Application for a non-material amendment following a grant of planning permission.

Construction of 1 No. new two storey house (resubmission following A/31/19/PL). This application is a Departure from the Development Plan & affects a Public Right of Way.

Reference number:	A/55/19/PL
Date of decision	08/08/2019

Amendment to siting of proposed house on block plan to match position on approved topographical 1:200 plan.

Client: Mr & Mrs Jones	
Project Address: Land at the 9th Tee Ham Manor Way Angmering	
Drawing Title: Proposed Site Plans & Section	
Drawing Number: 1202.02.d	
Scale:	As stated printed @ A1
Date:	06/02/2019

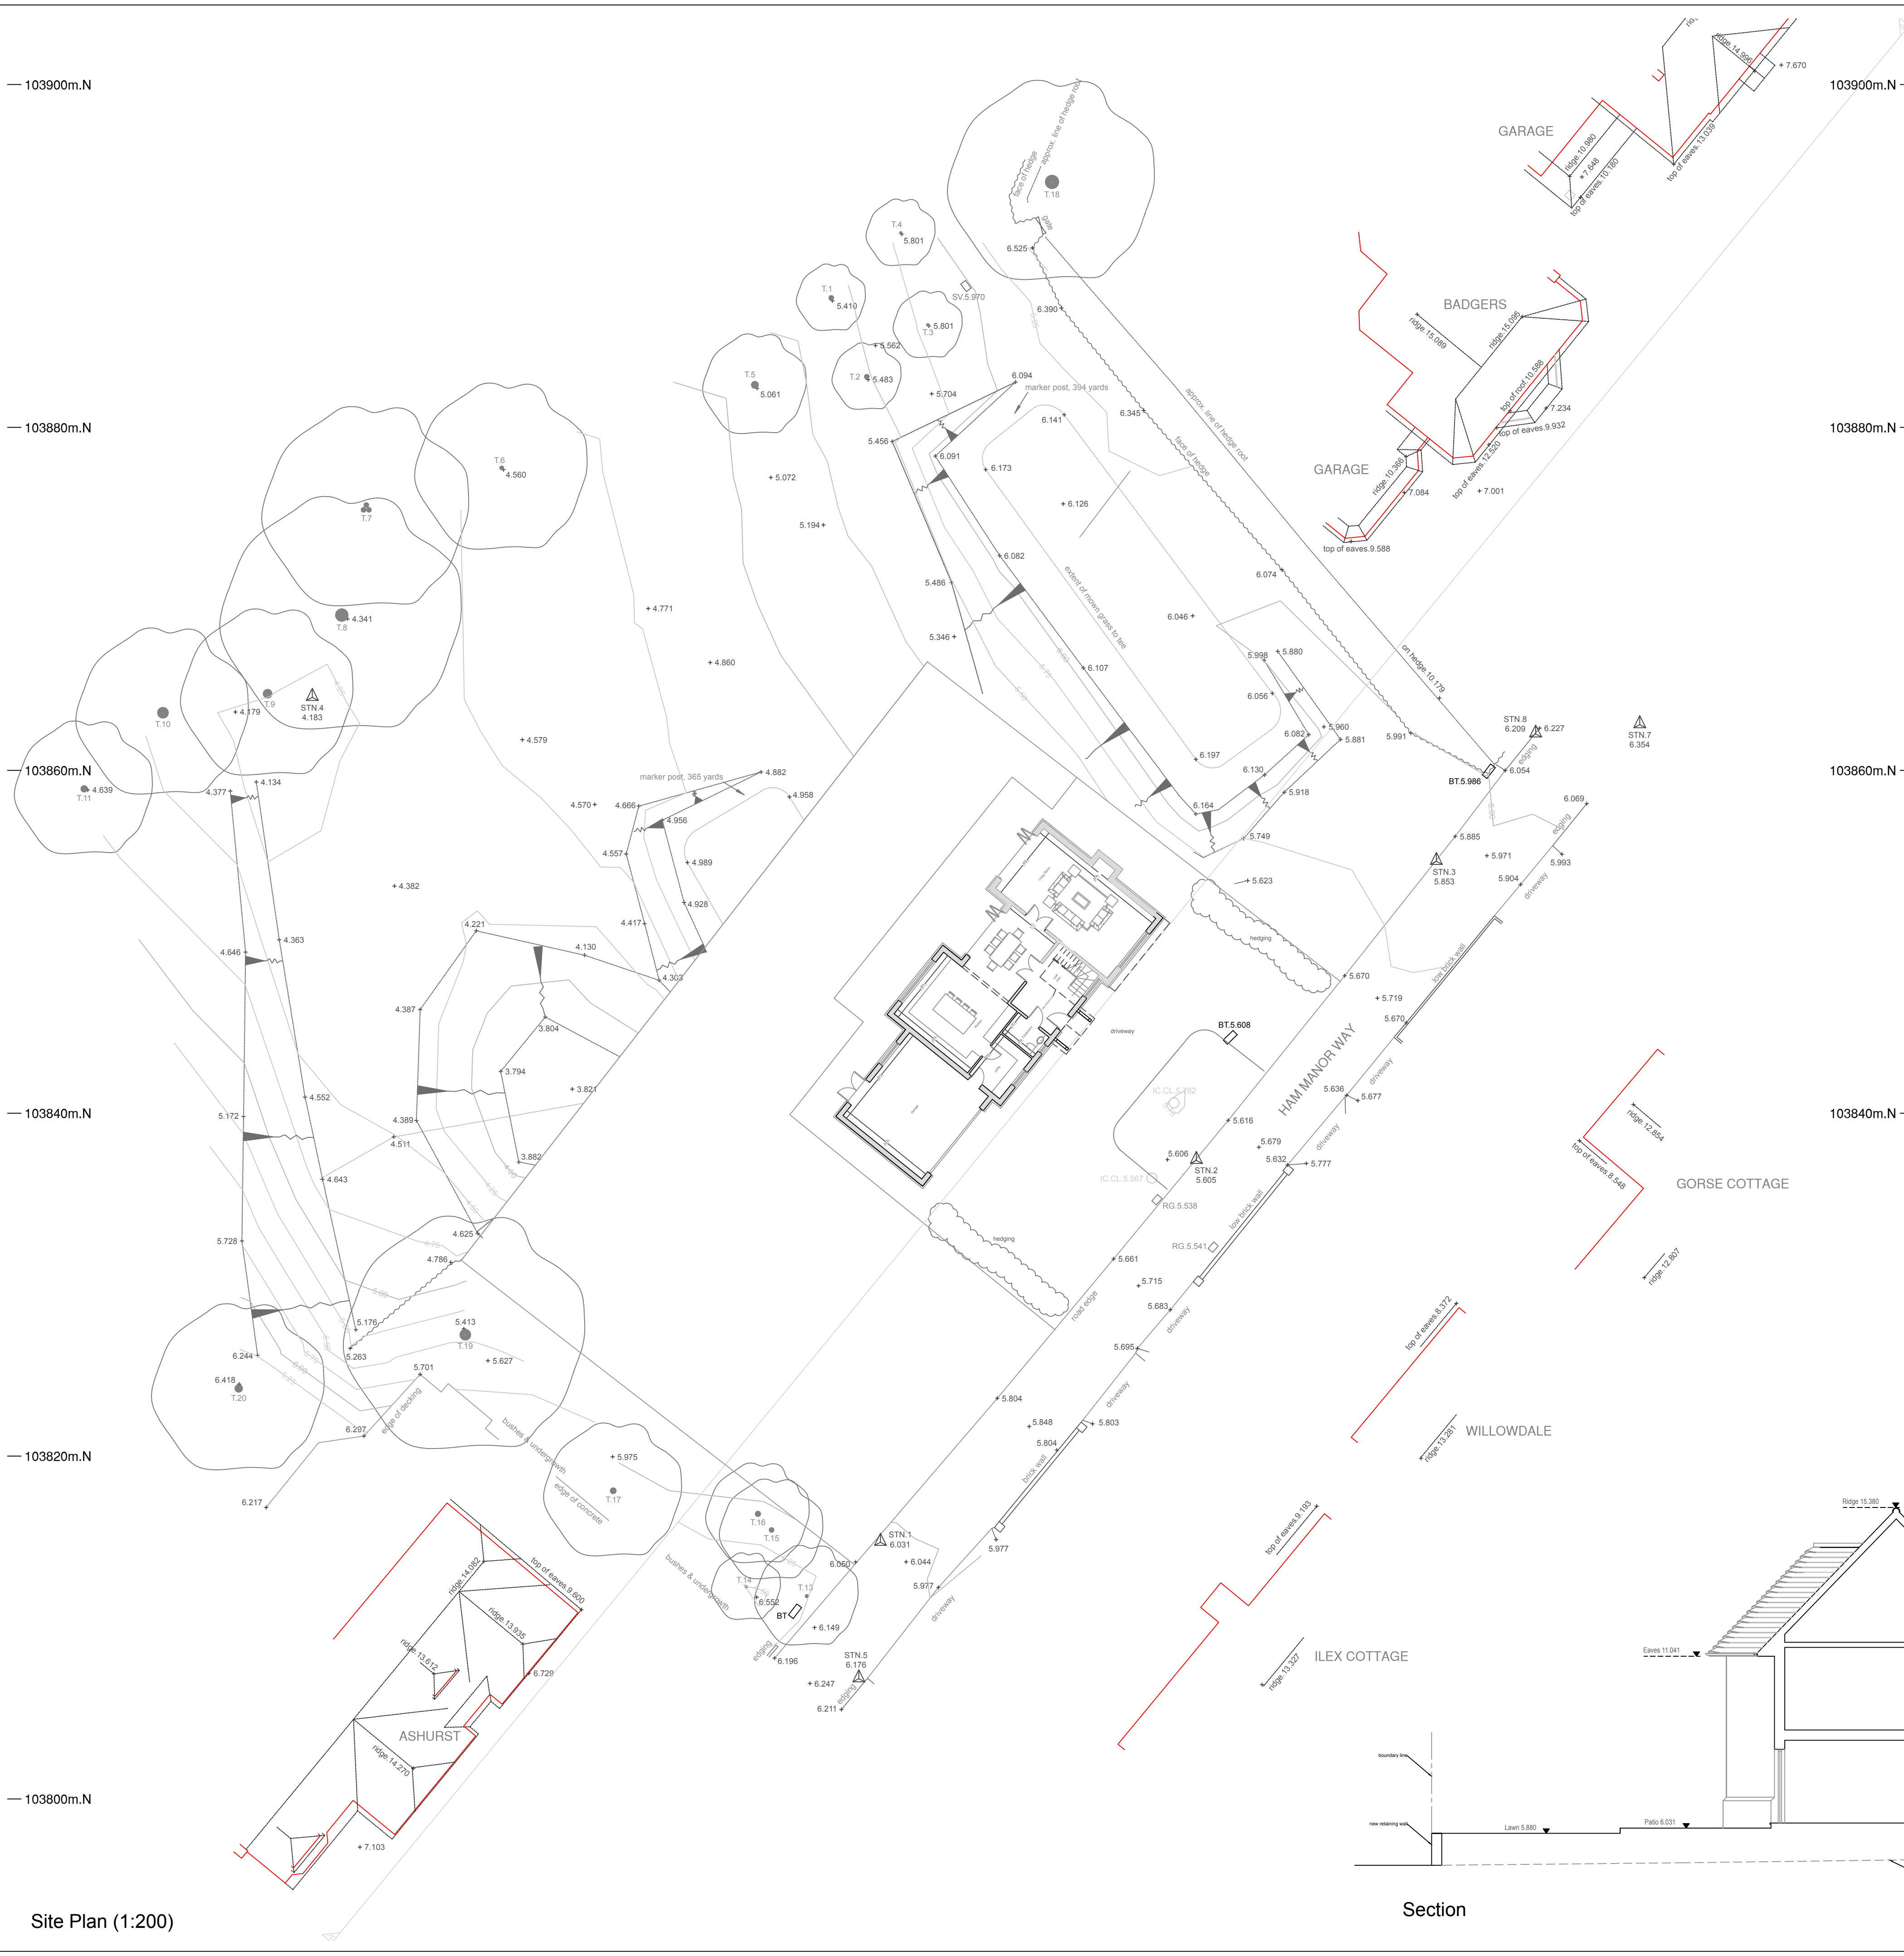
We are seeking and NMA to amend the siting of the house on the block plan. The red line is correct but the position of the house as shown previously (pink line) wasn't.

The perimeter of the site has been set out to the red edge in the block plan. The position of the house is as approved on the topographical plan (1:200 plan). The relationship to the surrounding houses is as shown on the topographical plan.
